Y/184/21/DOC – CONDITIONS 8, 9 AND 10: DRAINAGE RESPONSE

Thank you for returning comments from your Drainage Engineer pertaining to planning conditions 8, 9 and 10 under planning permission Y/184/21/DOC for the Crematorium, Bognor.

Job Title **Central Arun Crematorium**

Project No.	Originator	Volume	Lvl/Loc	Type	Role	Number	Rev
13591	CRH	XX	XX	DR	C	5303	P1

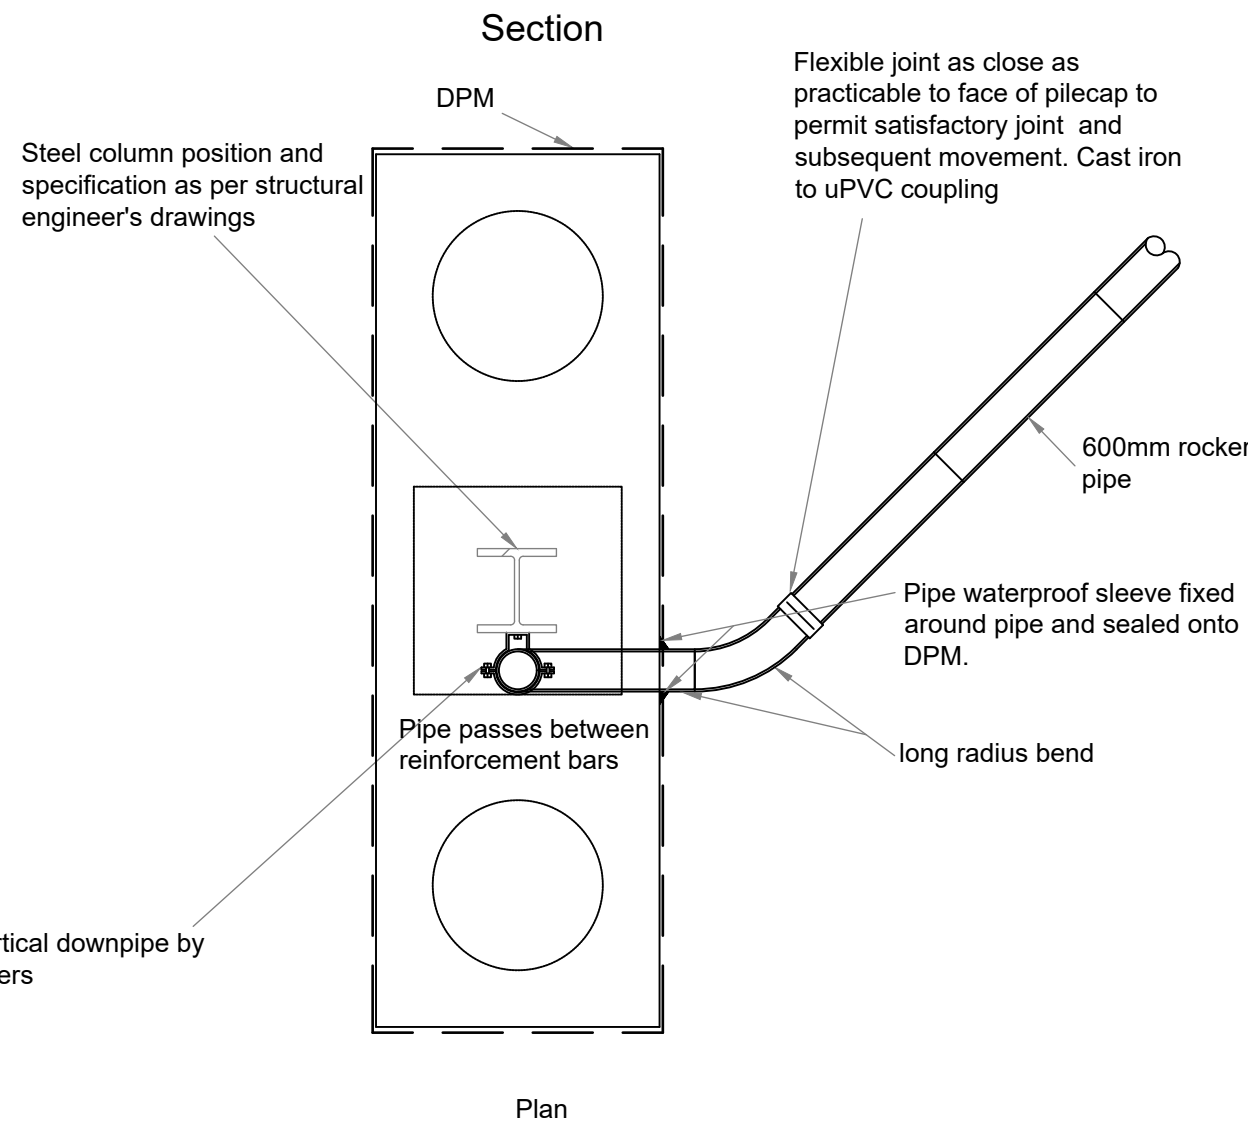
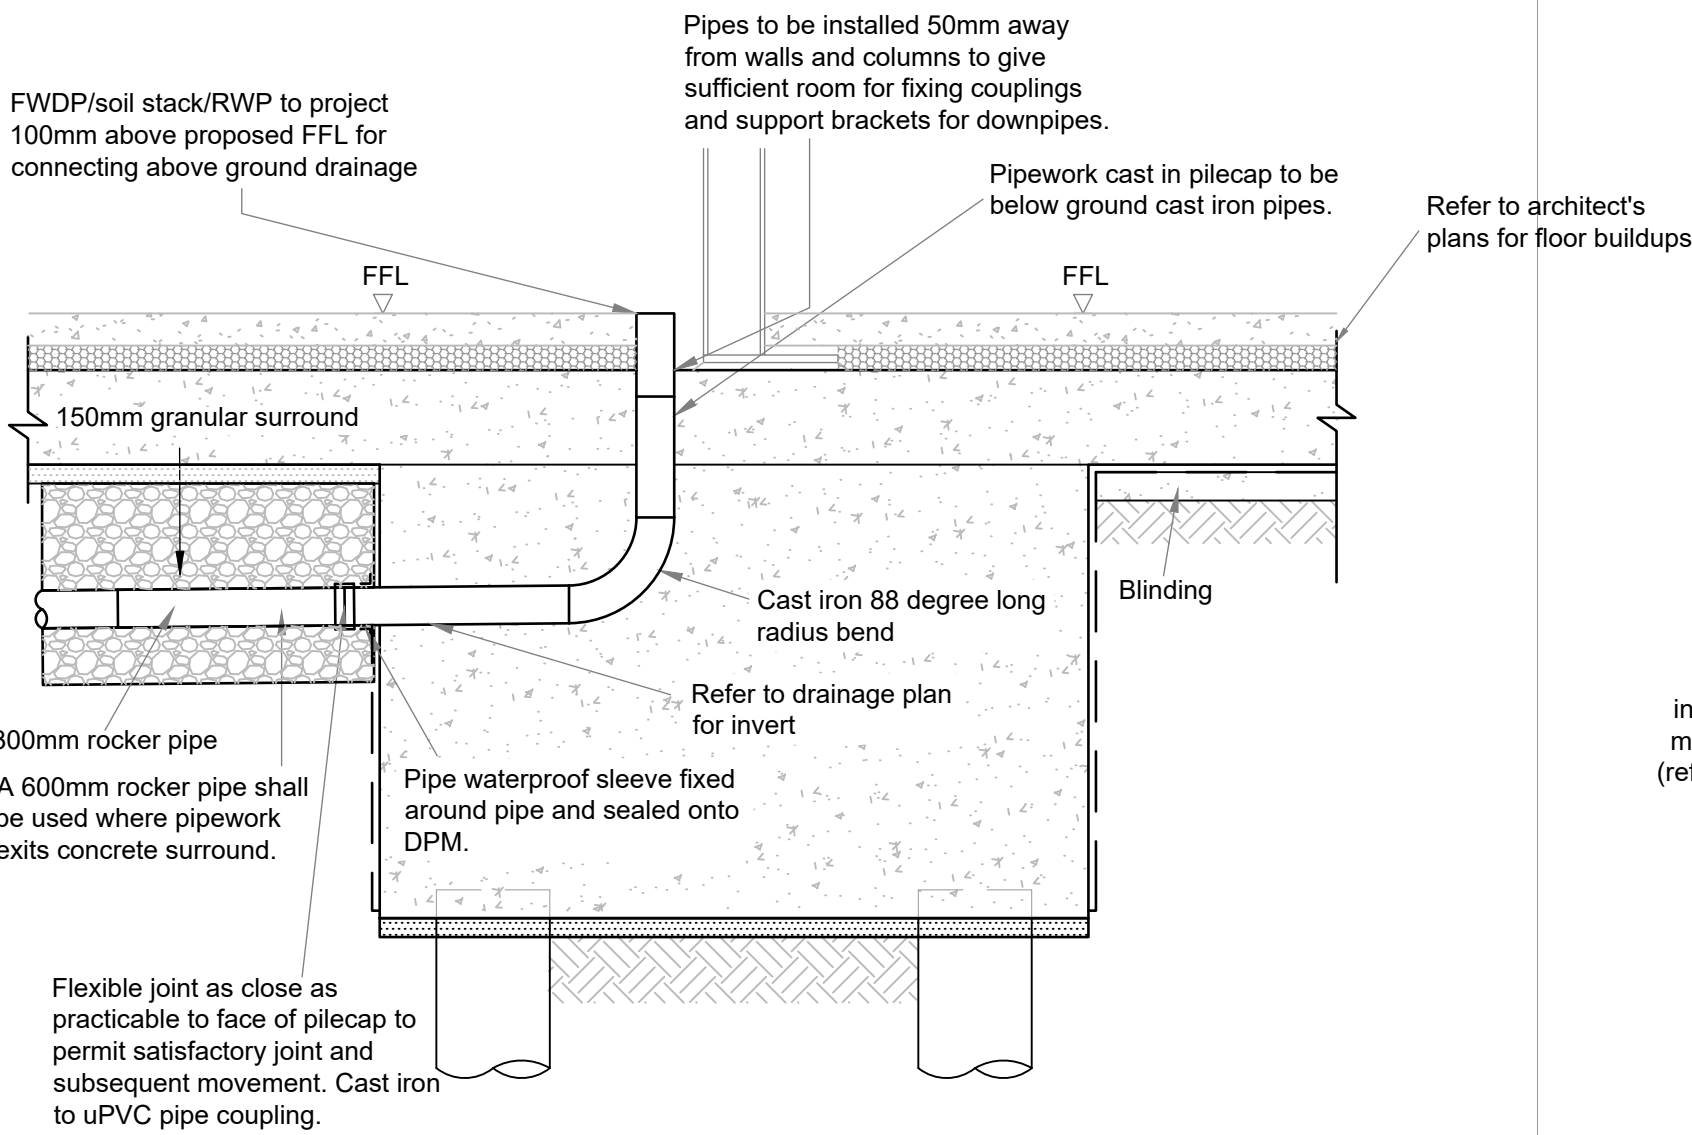
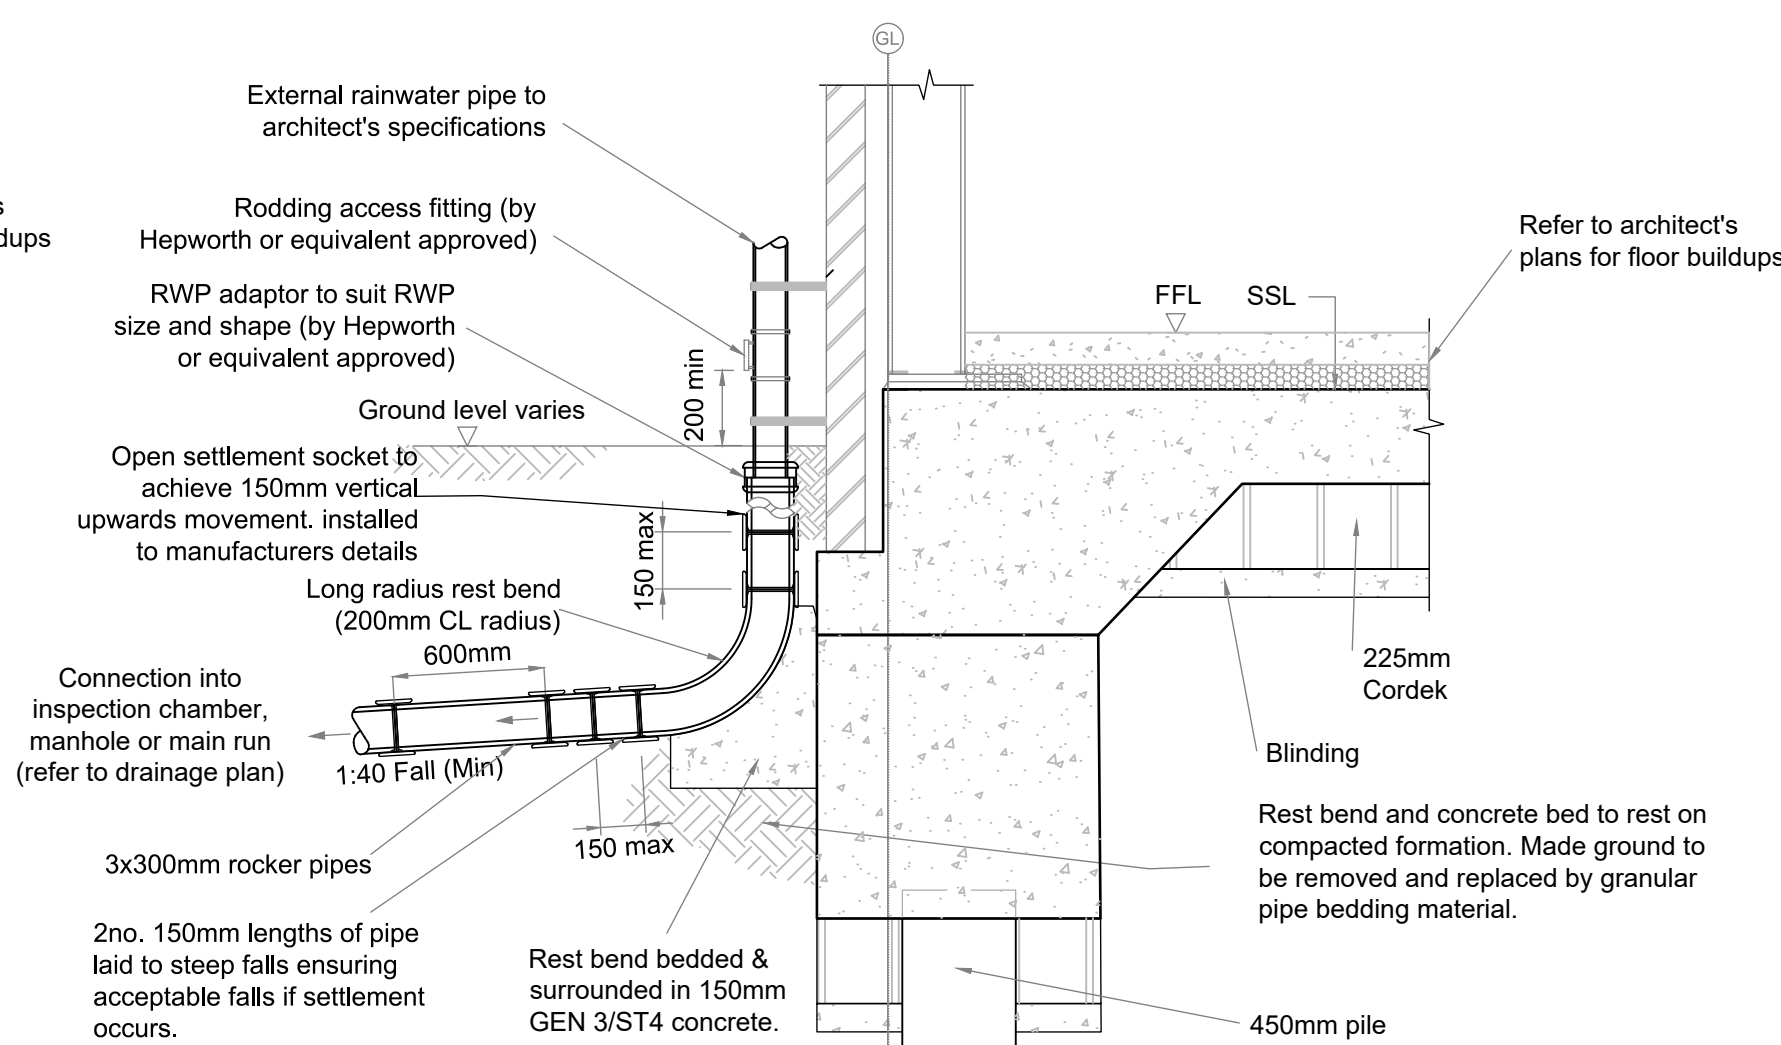
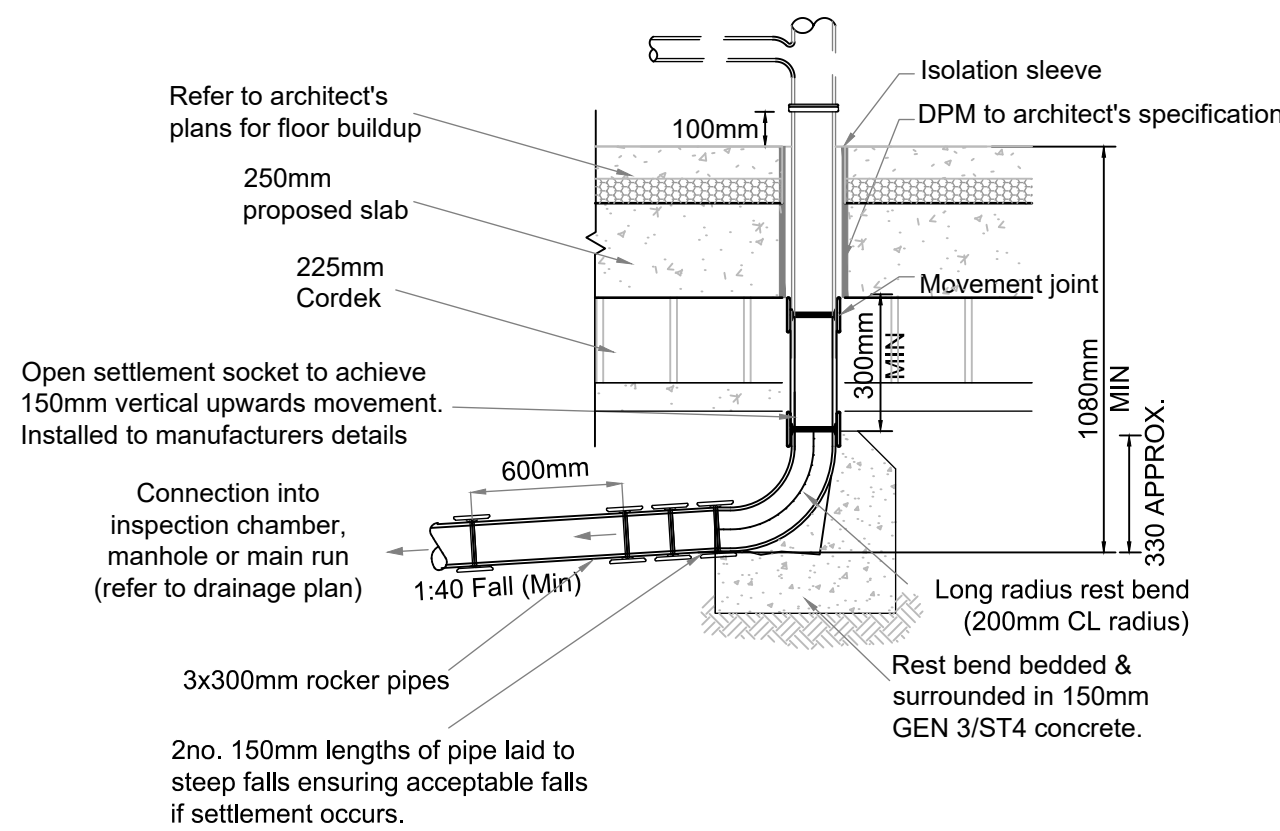
1. *Please supply results of winter groundwater monitoring and winter infiltration testing.*
2. *Please supply calculations to support design.*
3. *Please supply an impermeable area catchment plan.*
4. *Please label all pipes with diameter and fall.*
5. *Hydrobrake unit references should be included on layout plans.*
6. *Please label finish and formation level of permeable paving.*
7. *Gullies and channel drains should be labelled with cover levels.*
8. *The gabion outfall construction detail drawing is unclear. Is it proposed to have buried pipes discharging to the basin?*

8. The gabion basket is to be built into the embankment and to be exposed so as to be accessible for maintenance. The pipework will be within the basket and wrapped in a permeable membrane to prevent build-up of fines. The gabion provides siltation protection as well as dispersal of incoming flow to reduce scour. The gabion basket also removes the need for a traditional headwall and grille, reduces the maintenance requirements and provides a bigger area of contact/surface flow.
